**Town of Addison
Summary of Engineering Revision Comments**

Development: Galaxy FBO

Town Project #:19-09D

Town of Addison Engineering Review Conditional Civil Approval

SHEET NUMBER
C03.02

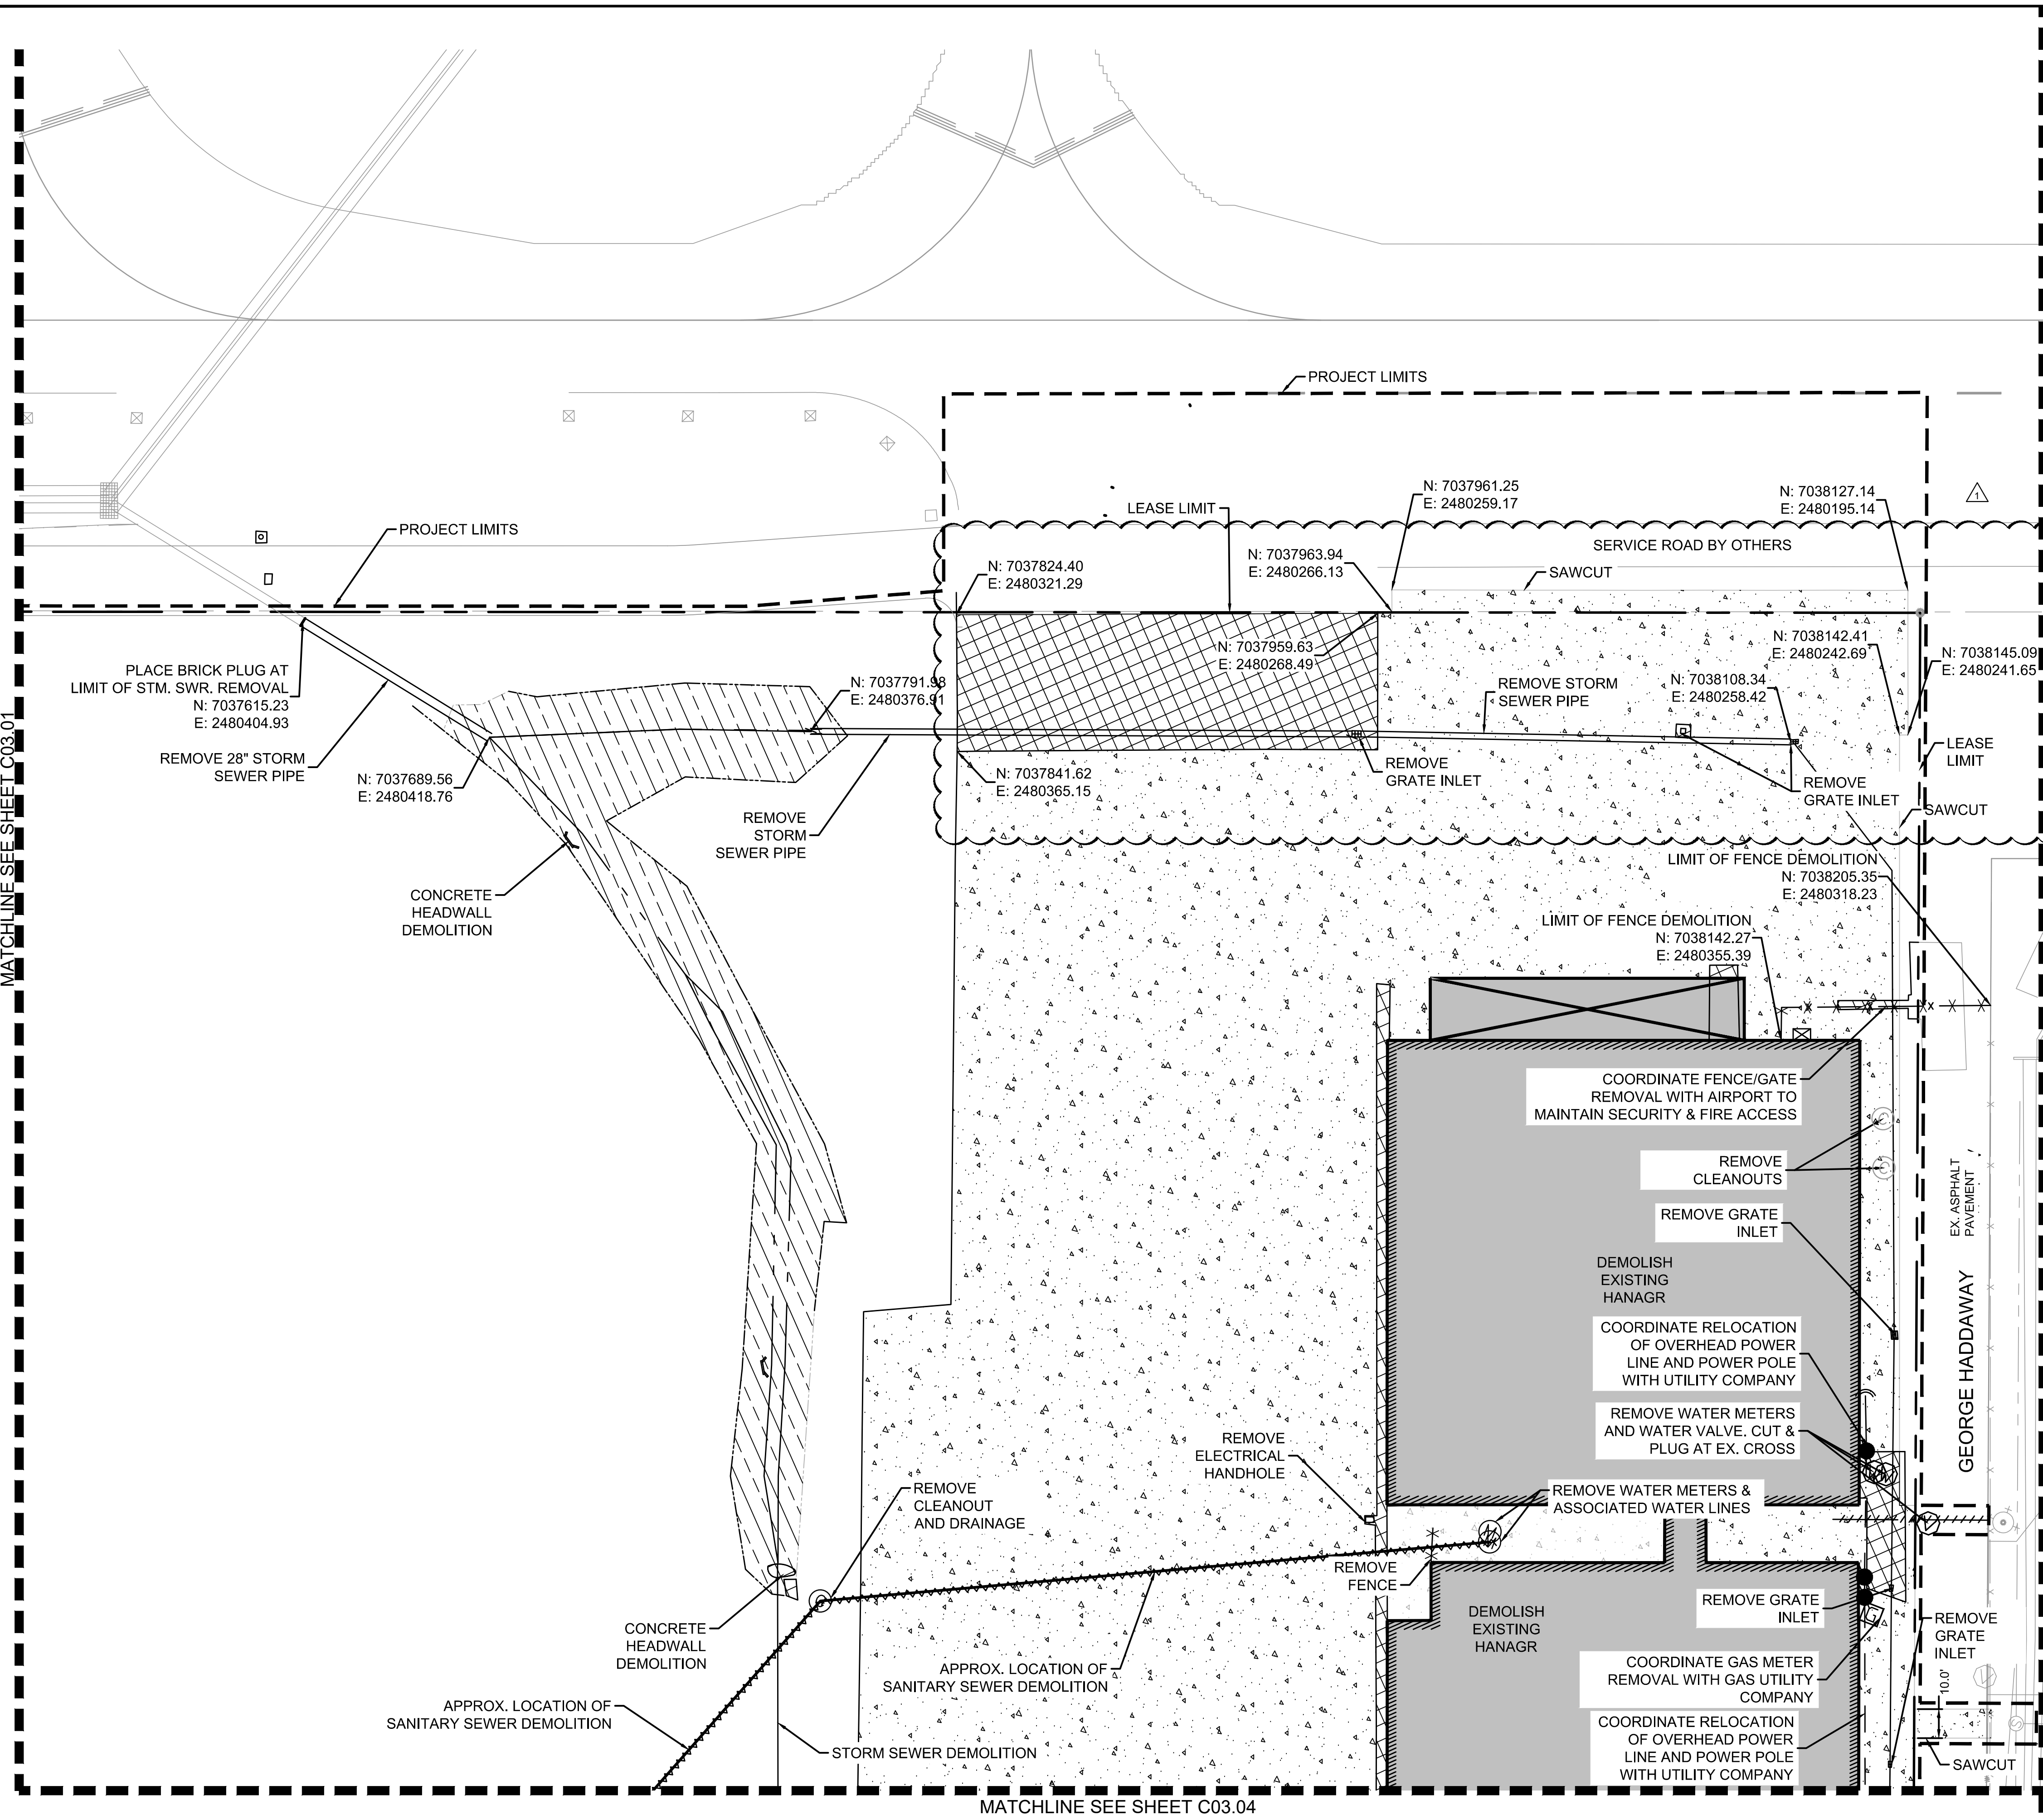
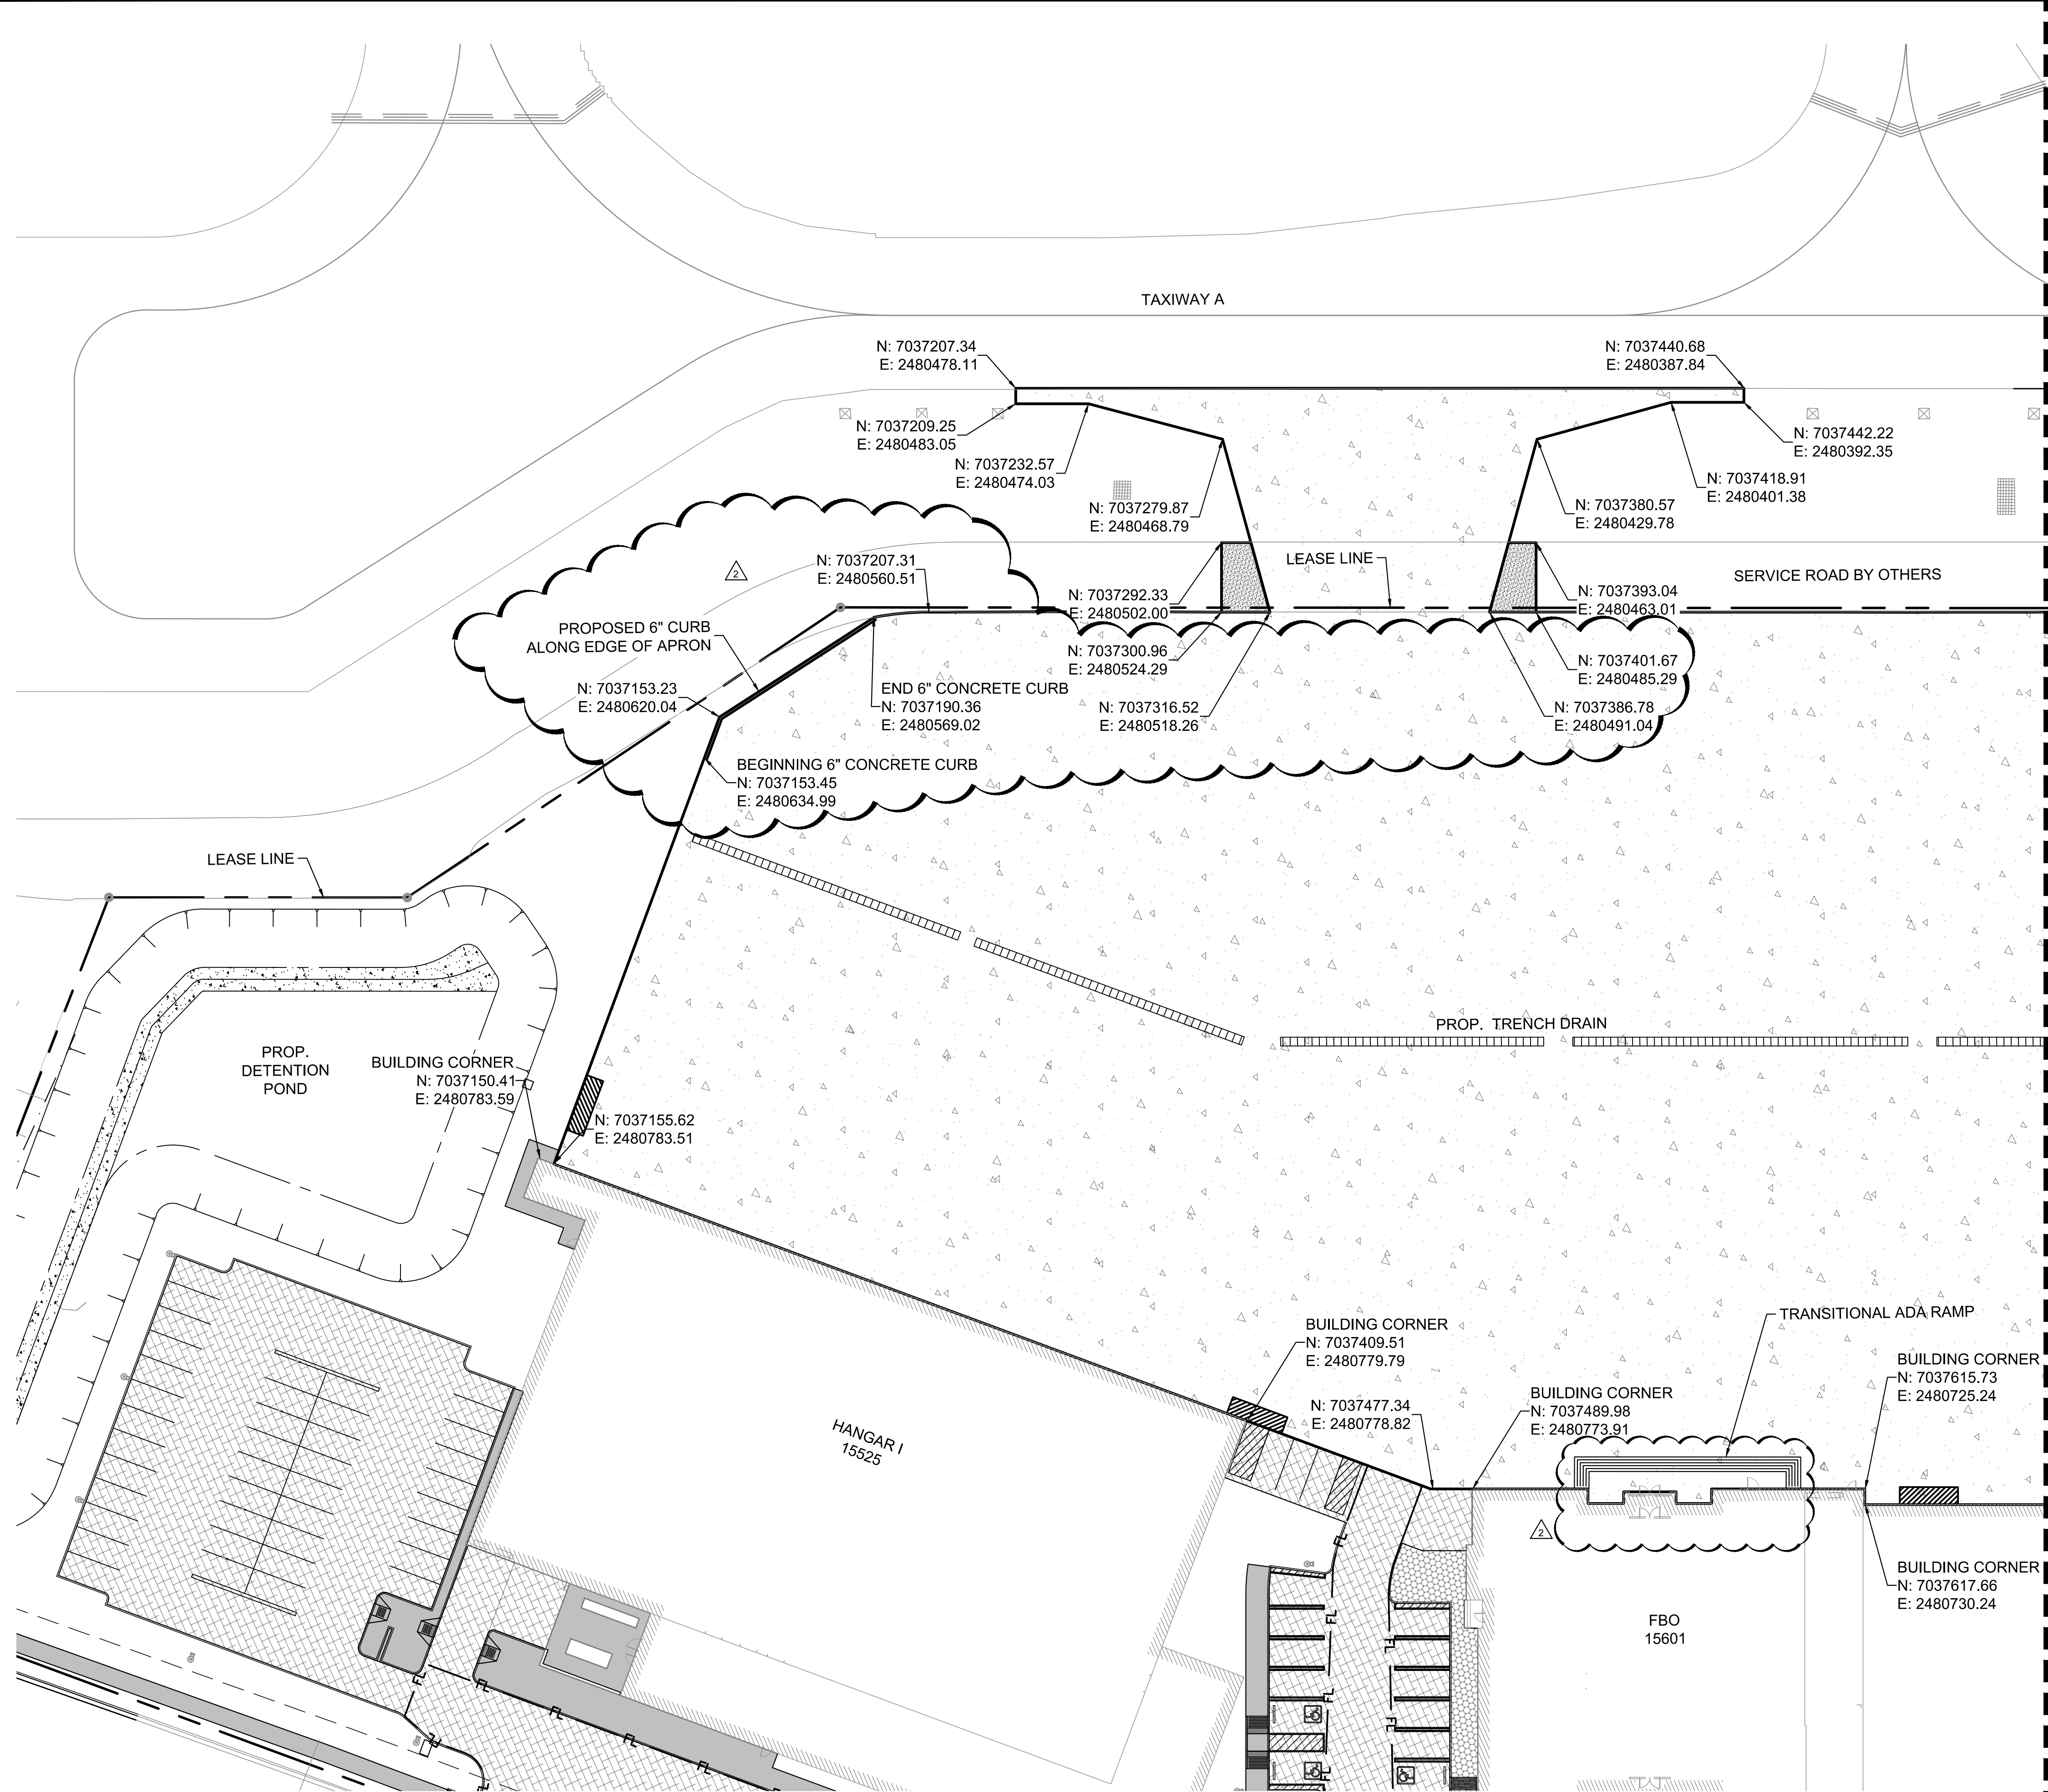
Revision No.	Date	Page No.	Comments	Reason for changes
ASI-C006	10/30/2020	C03.02	Updated the demo limits along the edge of the perimeter road per field conditions verified by a construction progress topographic survey.	
ASI-C006	10/30/2020	C04.01	Updated apron layout/geometry per field conditions verified by a construction progress topographic survey.	
ASI-C006	10/30/2020	C04.02	Updated apron layout/geometry per field conditions verified by a construction progress topographic survey.	
ASI-C006	10/30/2020	C05.01	Updated door locations on Hangar 1 to coordinate with revised architectural plans.	
ASI-C006	10/30/2020	C05.03	Updated door locations on Hangar 3 to coordinate with revised architectural plans.	
ASI-C006	10/30/2020	C06.01	Updated joint layout based on the minor apron layout/geometry changes.	
ASI-C006	10/30/2020	C06.02	Updated joint layout based on the minor apron layout/geometry changes.
